Appeal Decision

Decision date: 26 August 2022

Appeal Ref: APP/R5510/W/22/3299301

Wood Lane, Hillingdon, Ruislip HA4 6EY, X509065, Y186962

150 EXISTING SITE ELEVATION

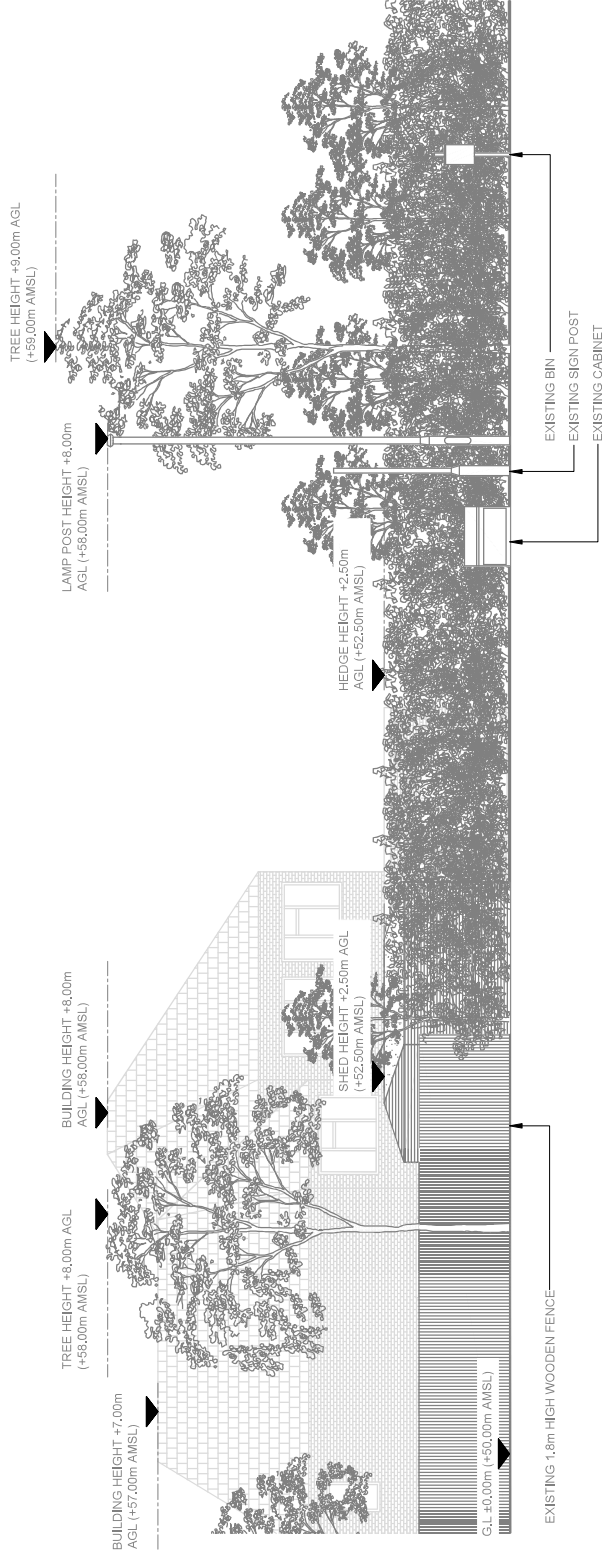
6. The verge contains other human elements near the appeal site, such as lamp posts, a bin and a small cabinet. However, the introduction of a 15m monopole tower and associated equipment would have a much stronger presence in the verge due to the height of the tower. The tower would have a functional and utilitarian appearance that would be prominent as it rises above the trees and lamp pole. The colour treatment proposed would help but it would not mitigate such effects. In this regard, it would erode the verdant qualities of the Lane to the detriment of this part of the CA.

7. Due to the height of the tower the proposal would be clearly visible from several of the nearby residential properties. The pole would be sited very close to the rear garden of No 2 Helford Close (No 2) and, to a lesser extent, No 3 Helford Close (No 3) and No 4 Whitstable Close (No 4). From within the garden of No 2, the tower would rise significantly above the garden fence and at such close proximity to the garden it would be unduly oppressive. This would significantly harm the living conditions of the occupiers of this property.
